Application Number W6/2015/0391/EM

Description of Development Erection of single storey rear extension

Recommendation Approve with conditions

Drawing No: 3192-P100 Revision: A

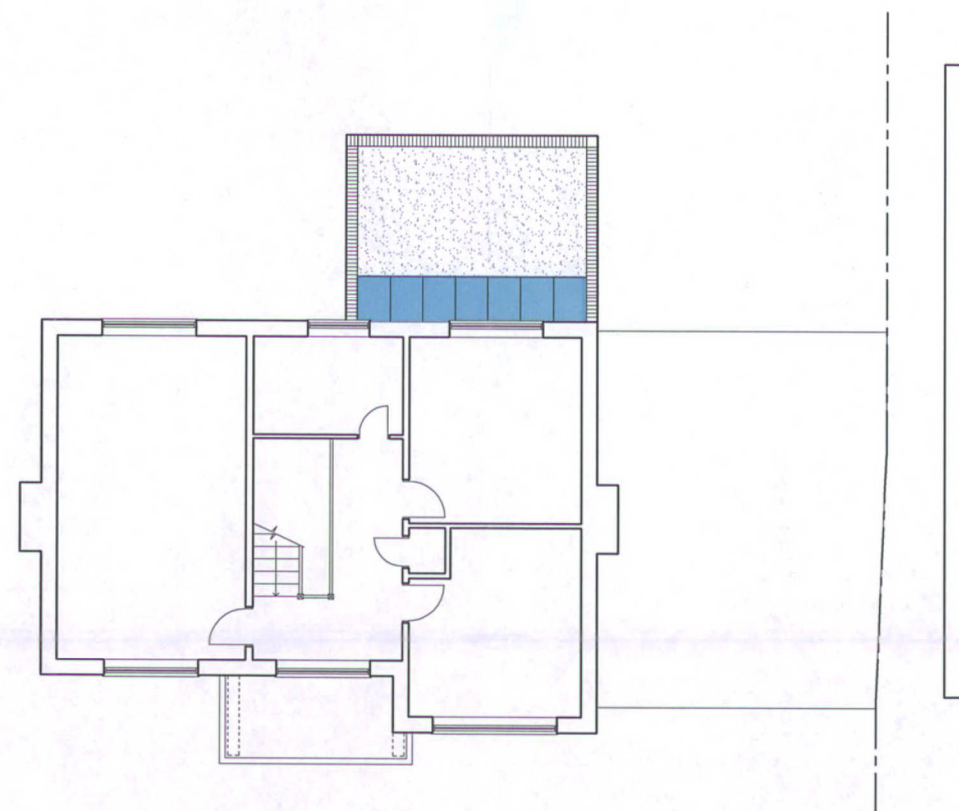
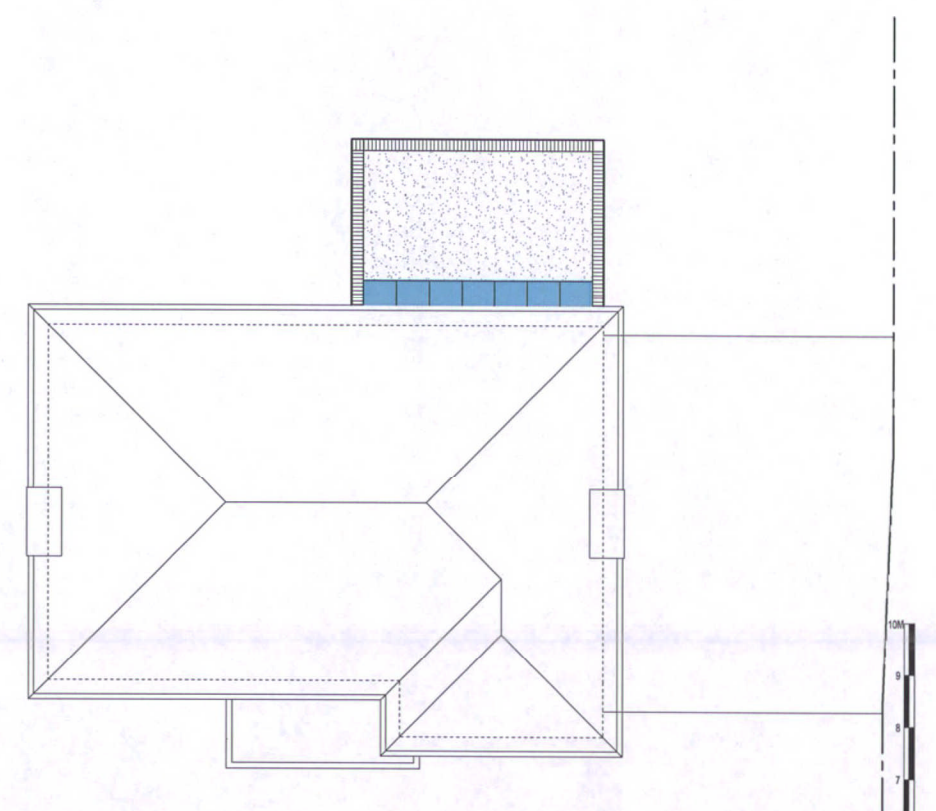
Comment: The proposed extension is a modest extension and together with the previous extensions at the dwelling would appear subordinate in scale to the original dwelling. It would have no discernable presence in the street scene given its siting to the rear of the property.

The extension is designed with a flat roof characteristic of the garden city. Although the fenestration would not match entirely, it is at ground floor and a more relaxed approach can be taken.
